**AJB/DBB/10520**

**08 May 2017**

**Proposed Conversion of Agricultural Barn to Residential Use.**  
**Reconfiguration of Accommodation and Adjustment of External Wall**  
**Openings.**  
**Austin Grounds Farm.**

Drawn By: NF  
Drg.No: HOP/02  
Revision: -  
Status: PROPOSED

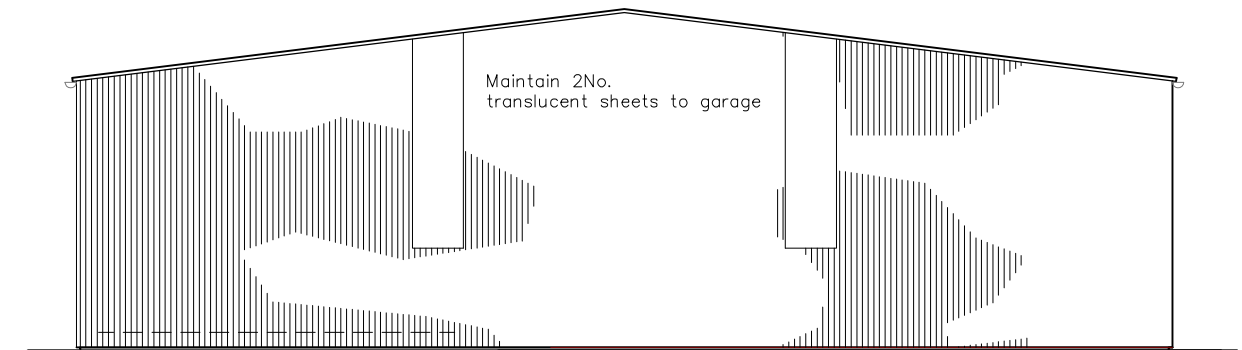
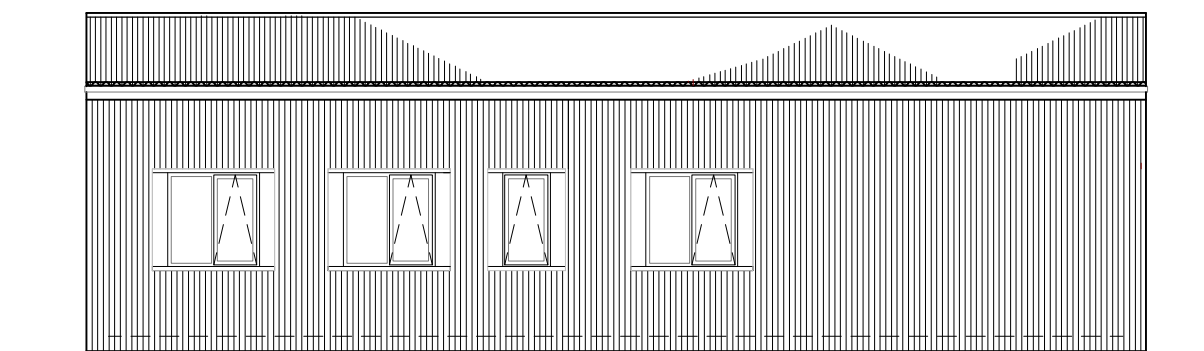
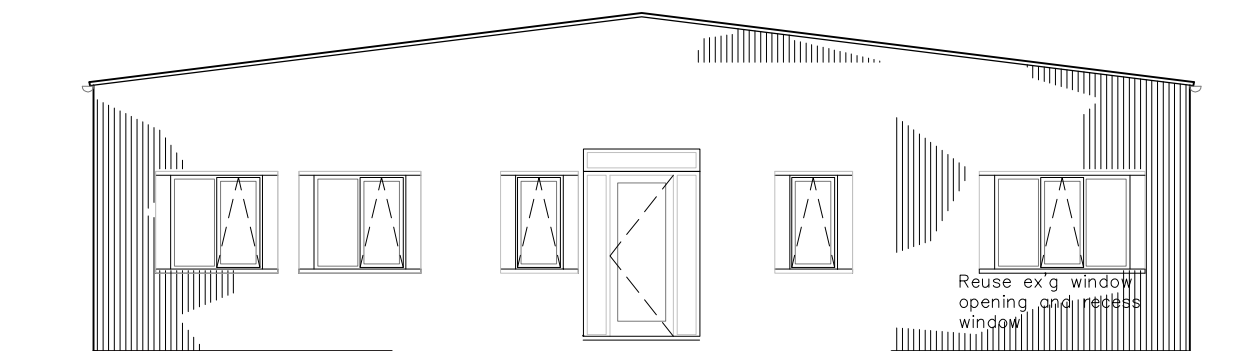
I can confirm that I have reviewed the plans by Freeborough Architectural Services Ltd, drawing numbers HOP/01 and HOP/02. These differ slightly from the original drawings by Graham Campbell, drawing numbers HOP/15/01B and HOP/15/02A, which my original report dated 20<sup>th</sup> May 2015 was based on. I attach a copy of the original report, for your information.

You have also confirmed that the existing fibre cement roof sheets are to be replaced with composite panels. This will actually reduce the dead load on the roof members.

Therefore, I can confirm that the slight alterations to the plans do not affect the integrity of the existing structure.
